District: Cherwell
Application No: 11/00282/DISC-2
Proposal: Discharge of Condition 30 of 08/00716/OUT-Aves Ditch and Portway
Location: Heyford Park Camp Road Upper Heyford Bicester Oxfordshire OX25 5HD

Transport Development Control

Officer's Name : Chris Nichols
Officer's Title : Transport Development Control
Date : 27 November 2018

Heyford Park
Proposed Footpath Re-alignments and Section

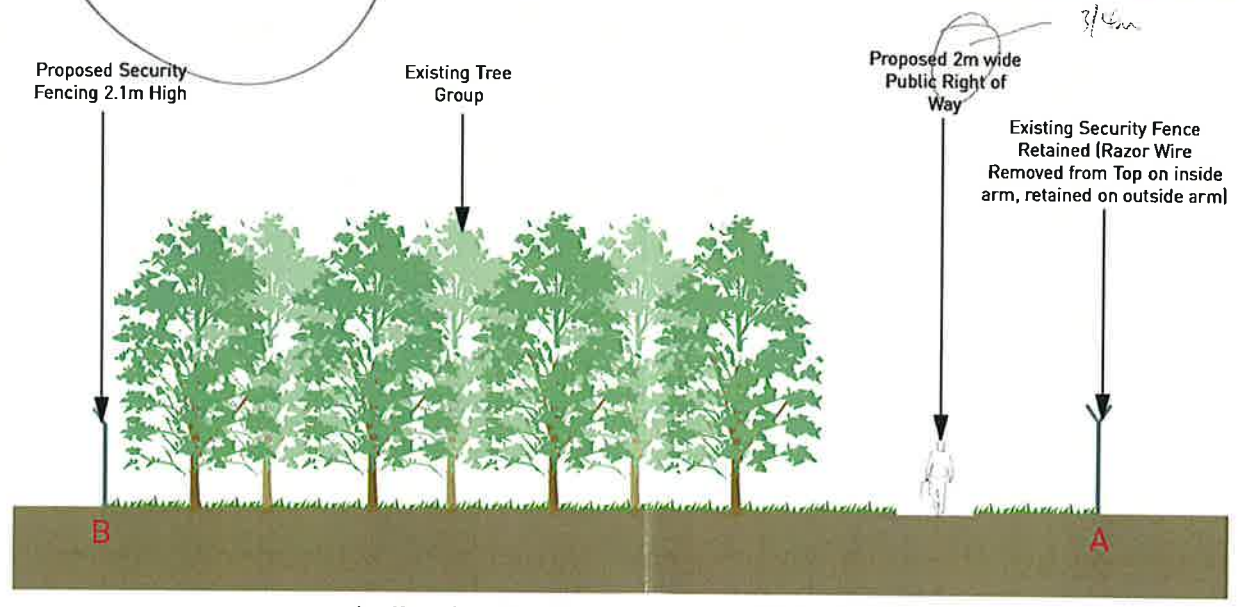
- Condition 30 – the proposals do not make any provisions for Aves Ditch.

The revisions to this application to discharge the condition in respect of Portway are fully supported. However, the application documents do not include any proposals for Aves Ditch which is an integral part of Condition 30.

The County can not recommend discharge of this condition until acceptable proposals are received for Aves Ditch.

In addition, it is requested that the works are required to be fully implemented including reopening of the whole route to the public within 6 months of the date of permission so that the route can be used ready for summer half term 2019. It is further requested that Aves Ditch route and reopening is undertaken to the same timescale. Once the County has this commitment it will enable works on connecting routes outside of the site to be programmed in.
